# City of Albuquerque

RE: DRAINAGE PLAN FOR VINEYARD ESTATES (C-20/D3)  
RECEIVED OCTOBER 16, 1987

RE: VINEYARD ESTATES DETENTION POND & BARSTOW STREET STORM DRAIN,  
PHASE II (C-20/D3) ENGINEER'S STAMP DATED JULY 18, 1991

RE: GRADING & DRAINAGE PLAN FOR VINEYARD ESTATES III, (C-20/D3)  
STAMPED & DATED 02-11-93, RECEIVED FEBRUARY 12, 1993  
FOR PRELIMINARY PLAT & ROUGH GRADING APPROVAL

DRAINAGE PLAN

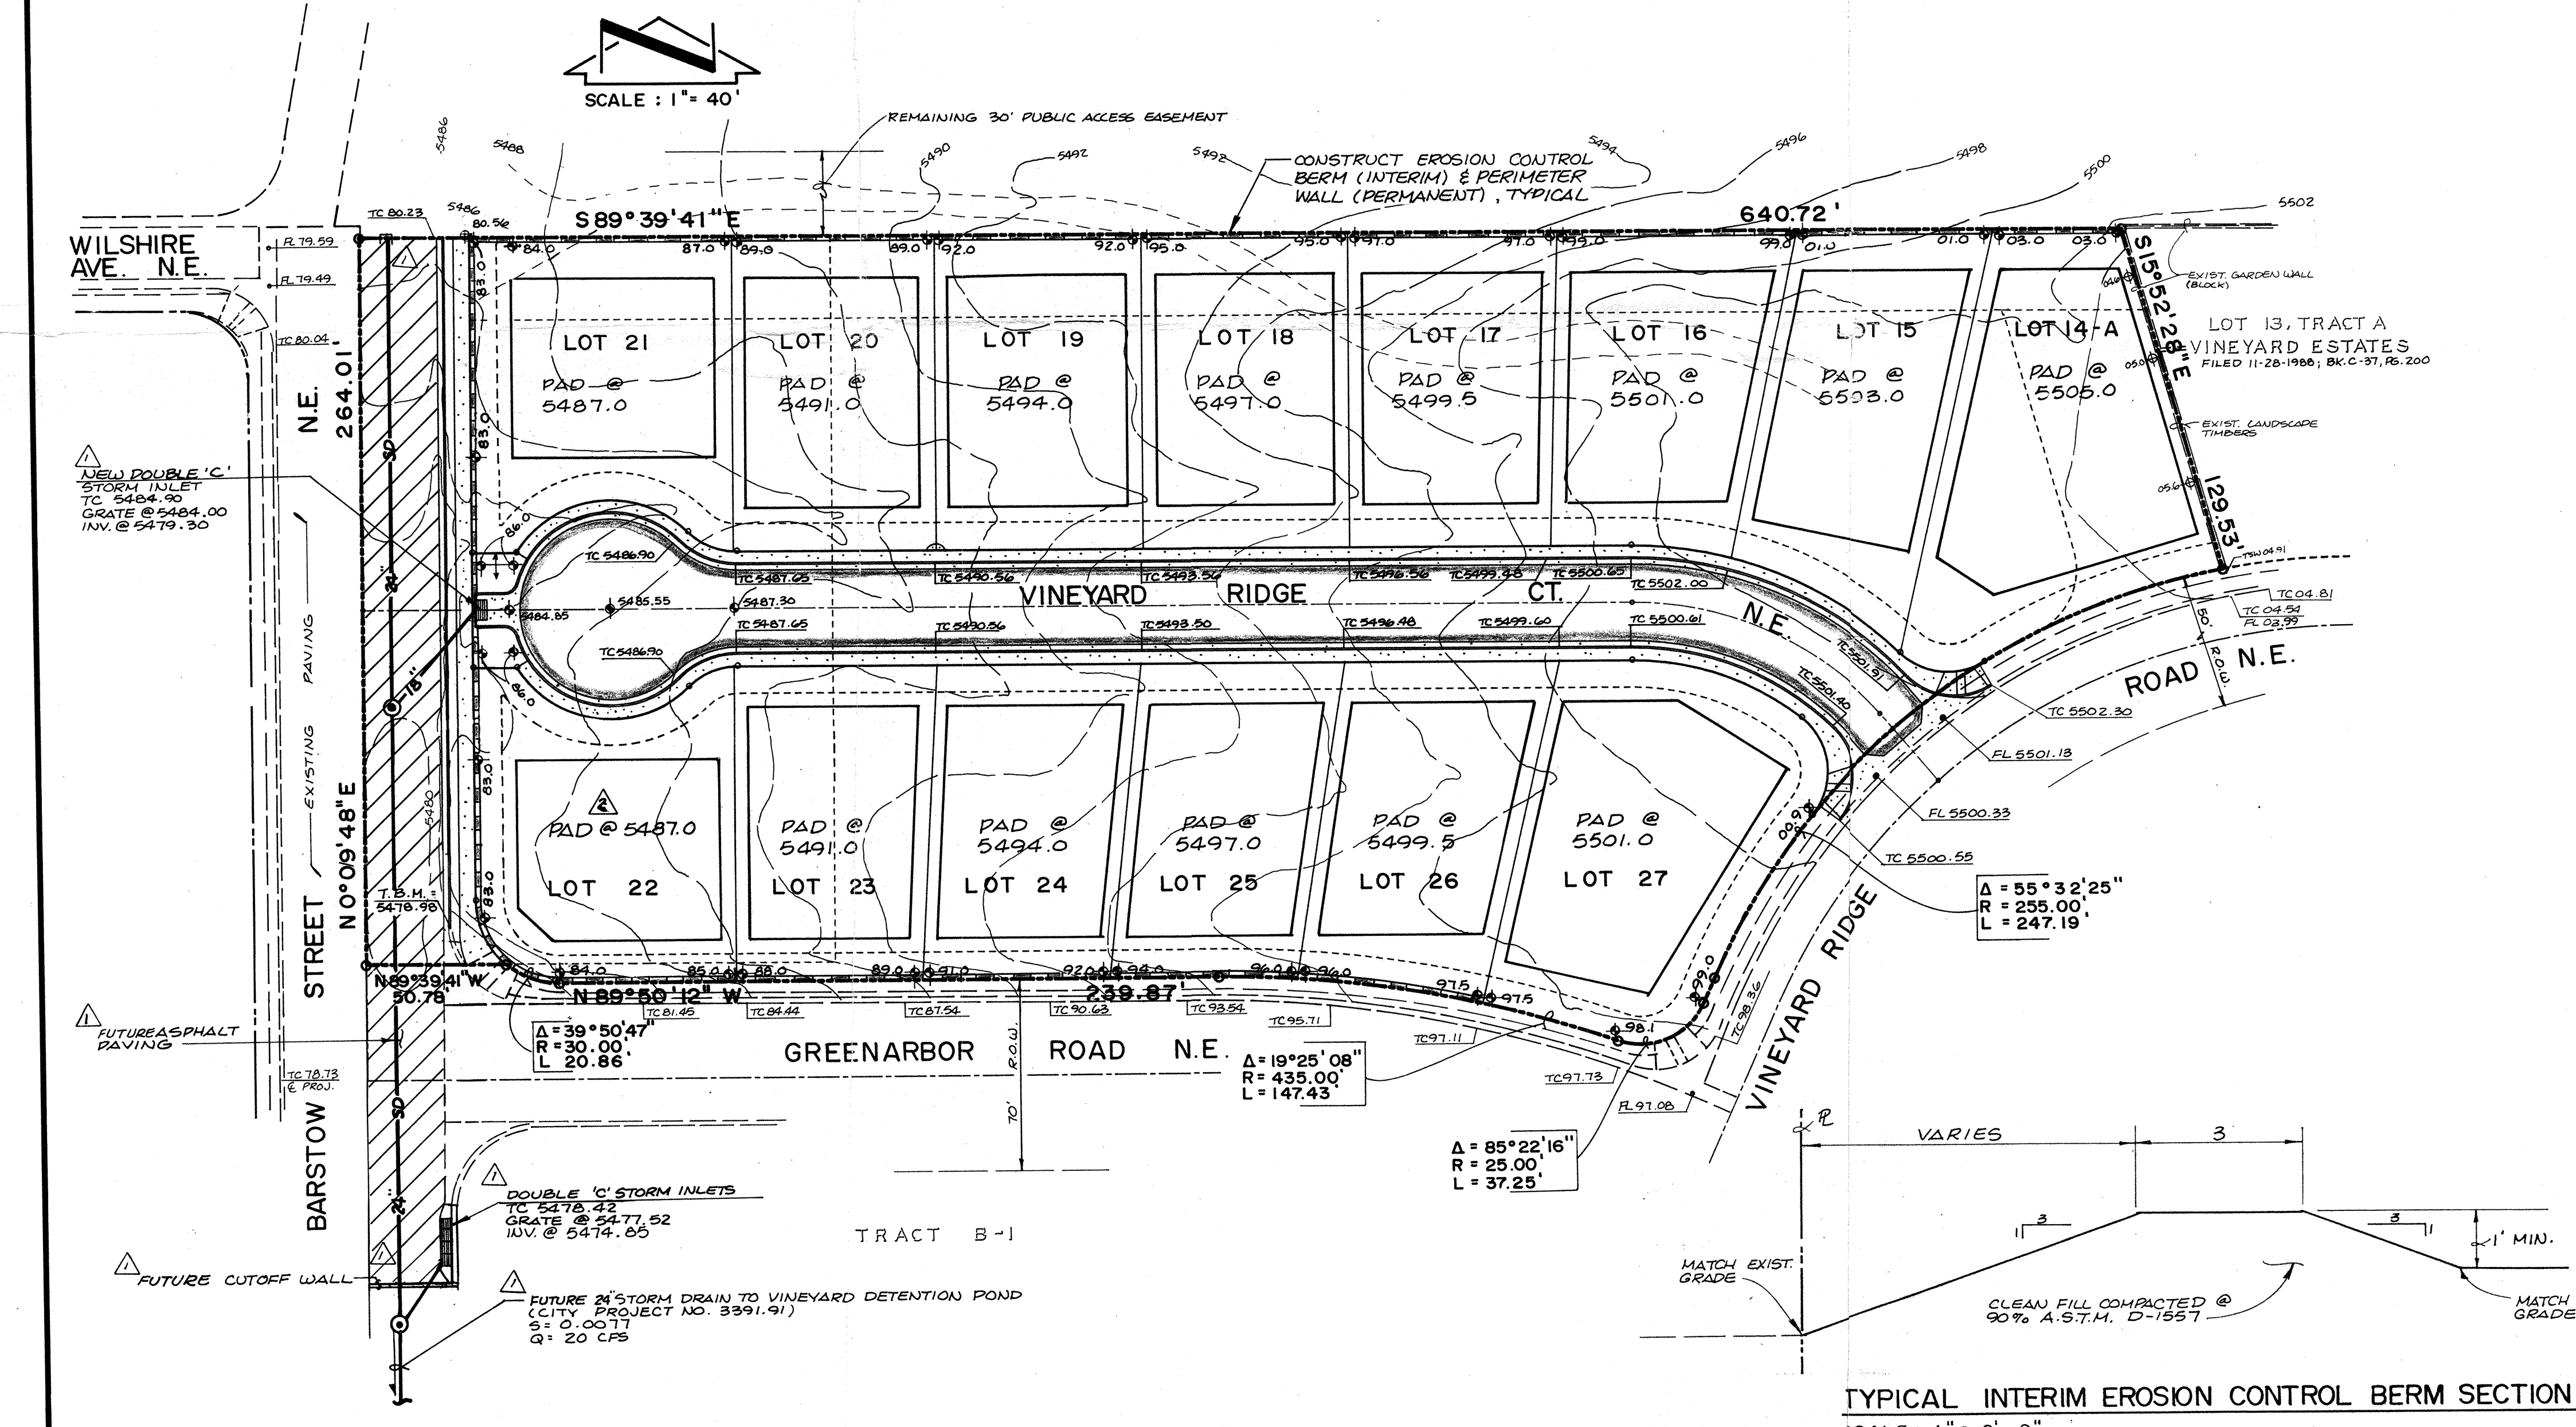
Prior to sign-off on the work order drawings, the following items are needed:

1. AMAFCA's approval for the pond on the APS site, Project No. 3391.91.
2. A hard lined swale is needed along Barstow Street between Project No. 3391.91 and No. 3391.92. The purpose of this swale is to assure flows remain within the R.O.W. or easement and to minimize erosion.
3. Revise Project No. 3391.91 to reflect the hard lined swale required in item 2.
